## Department of Primary Industries

### **Horsley Drive Business Park Stage 2 (SSD 7664) Comment on the Environmental Impact Statement**

DPI has reviewed the Environmental Impact Statement and provides the following comments:

31 January 2017

DRAWING TITLE BIO-RETENTION/OSD BASIN PLAN	
DRAWING No Co114 92.11- DA45	ISSUE D

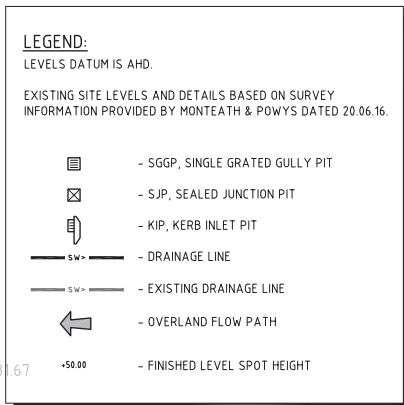
- The proponent should provide further detail regarding:
  - the riparian corridor that is proposed to be established around the detention basin, including the width of the buffer;

- the plant species proposed to be planted in this riparian corridor; and
- the location of the creek into which the outlet is to discharge.
